El Paso County PCD File No. XXX-XX-XXX

Revise to
PPR-21-033

Final Drainage Report
Gateway Trucking, LLC

# GATEWAY TRUCKING PROPOSED DRAINAGE MAP

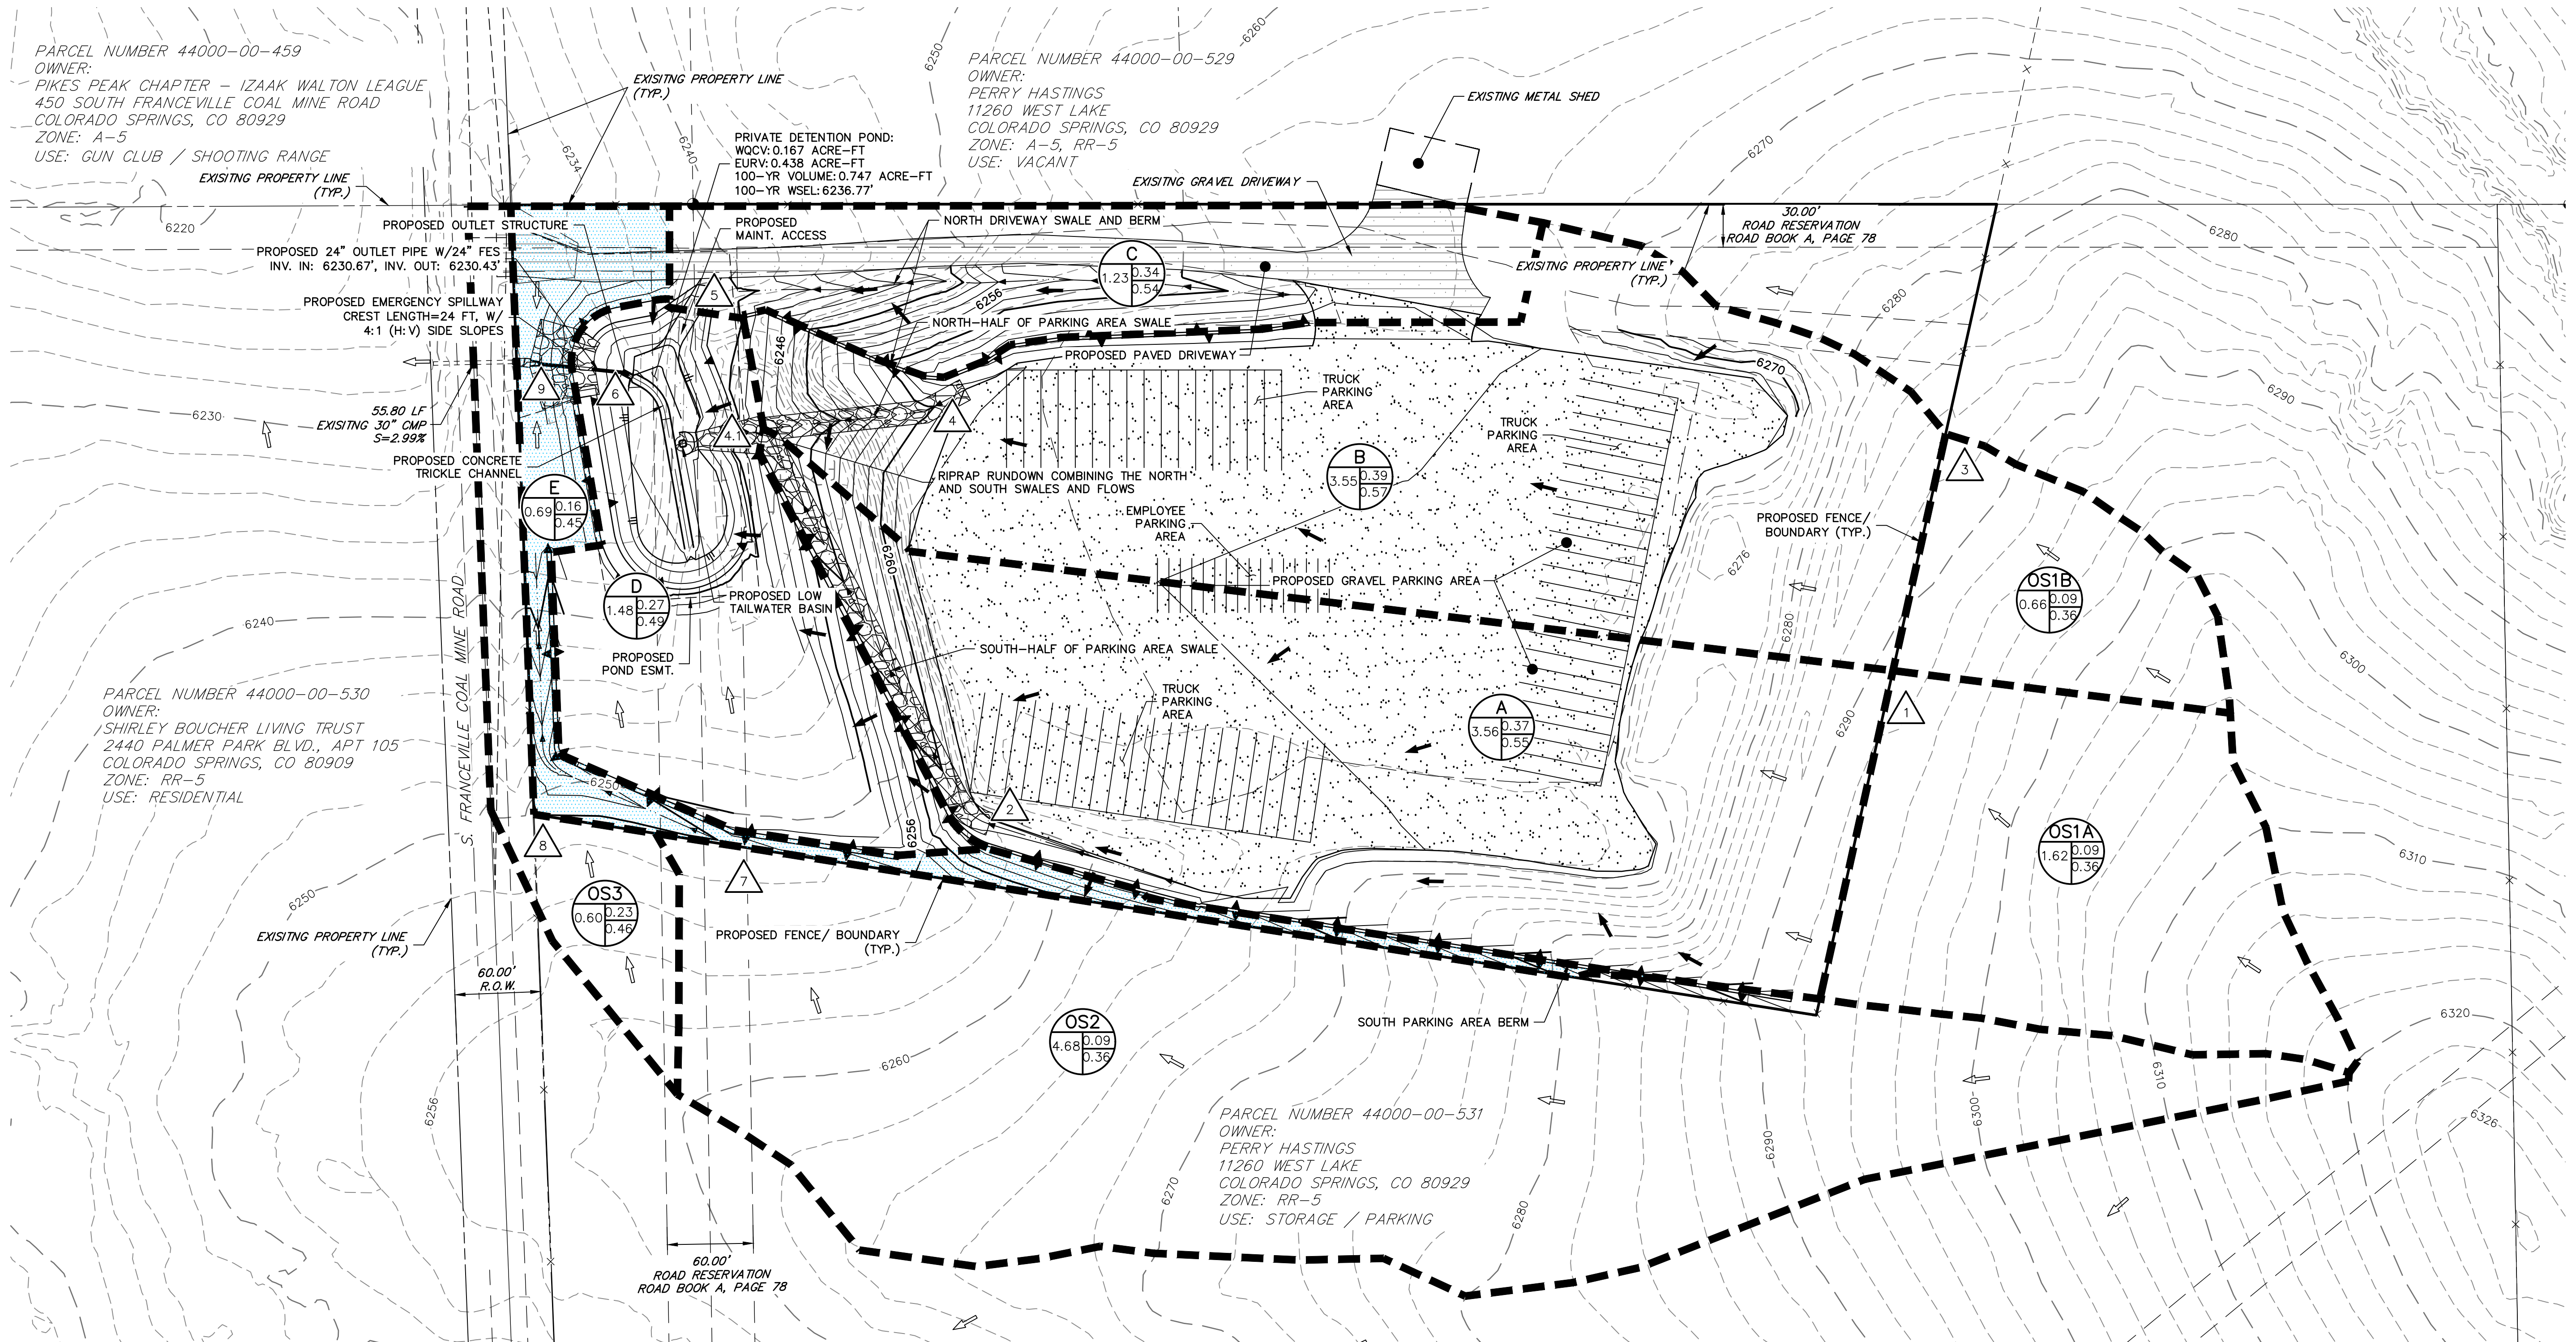
Add a statement identifying the specific permanent WQ exclusion. Reference the specific section of the criteria and summarize why the given criteria applies to sub-basin E.

See Appendix I Section I.7.1.B for the list of allowable exclusion. You will likely identify two specific criteria for your justification for not providing permanent WQ for Basin E

The likely exclusion is #7 (sites with land disturbance to undeveloped land that will remain undeveloped) for the southern portion of basin E.

2. For the driveway portion of basin E see Appendix I Section I.7.1.C.1.a which exempts 20%, not to exceed 1 acre of the development site area when it is not practicable to capture runoff that runoff and route to a control measure. In the summary text, identify the acreage of driveway in basin E and it's percentage of the development site
